From: planning
Subject: FW: app3/2017/0270 Creation of new Vehicular Access off Moor Lane

From: Bloomer, David [<mailto:David.Bloomer@lancashire.gov.uk>]
Sent: 24 April 2017 14:20
To: John Macholc
Cc: LHS Customer Service; planning
Subject: app3/2017/0270 Creation of new Vehicular Access off Moor Lane

Holmes Mill
Proposed Site Plan

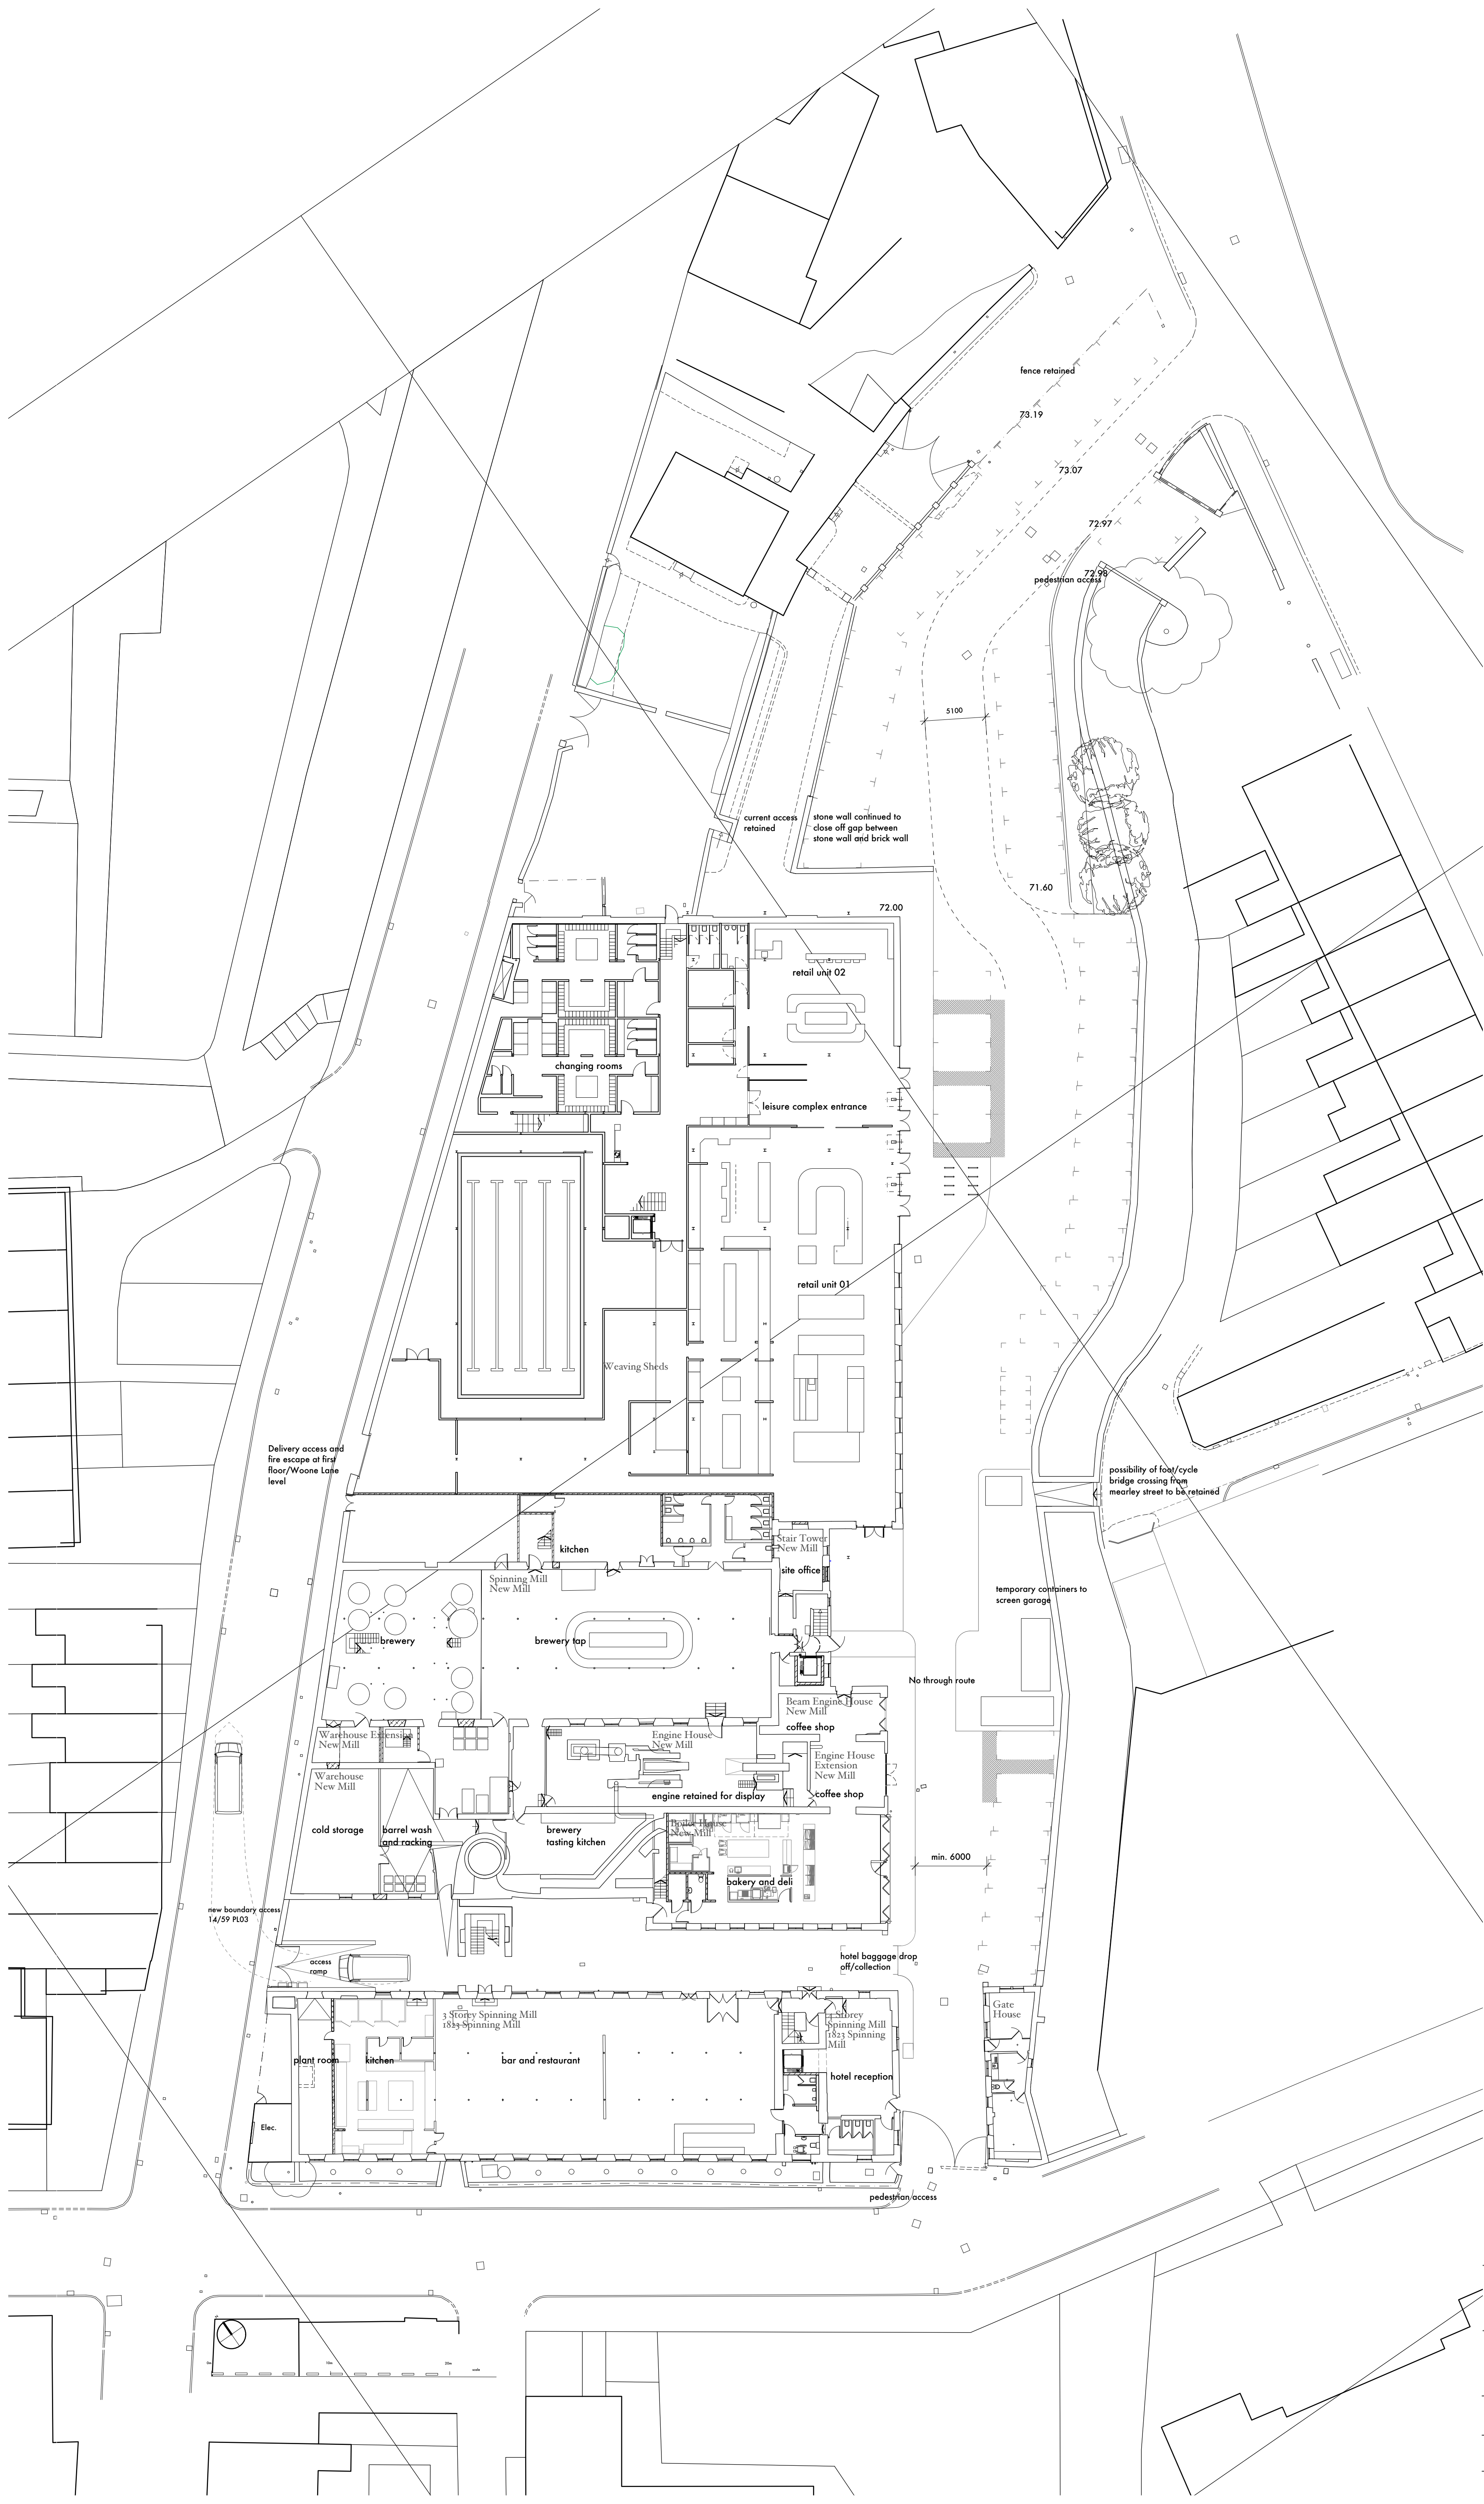
1 In a recent application for the site (app2017/0262) it was suggested that he proposed pedestrian / cycle link from Mearley Street would not be pursued. This being the case the new access proposed by this application should include adequate provision for pedestrians entering the site from Moor Lane. Unfortunately this provision is not clear from the information on plan 14/59SKPL3 A . I would need to see how this is to be achieved and also a safe pedestrian route through to the various elements within the site.

Holmes Mill
Proposed Site and Access Plan

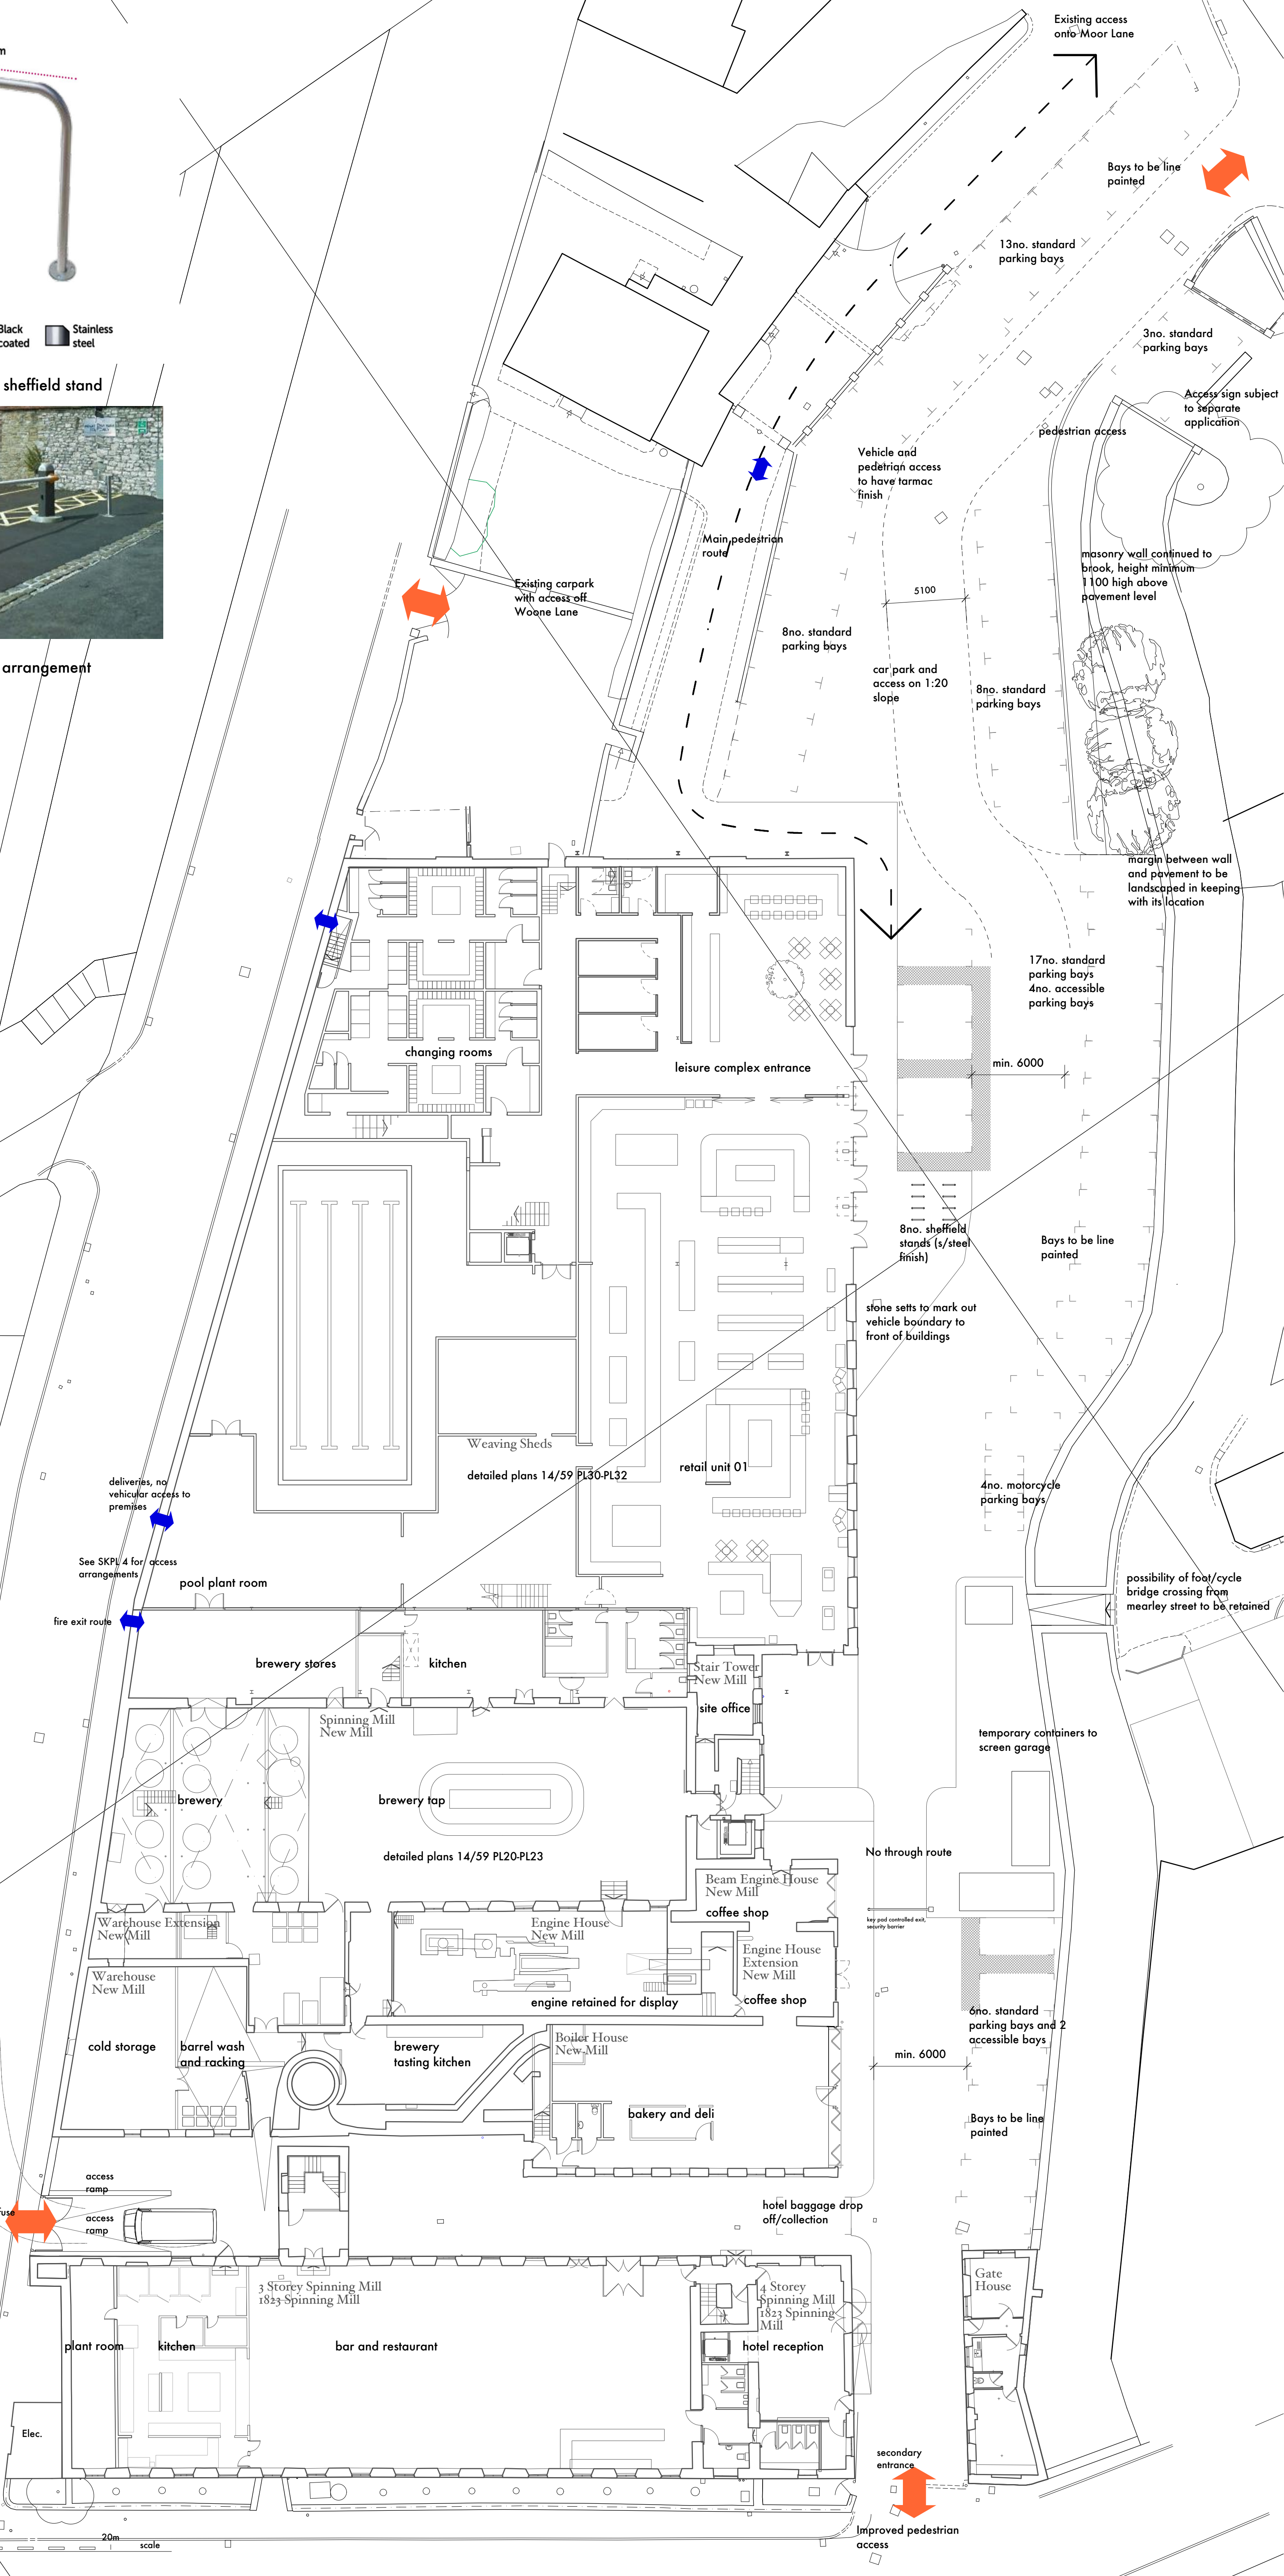
2 Similarly to item 1 above , mention has previously been made of a barrier to prevent through access between Moor Lane and Greenacre Street. The method employed and location of any such barrier will need to be shown on a revised plan . I think it will be necessary to Condition the provision of the barrier.
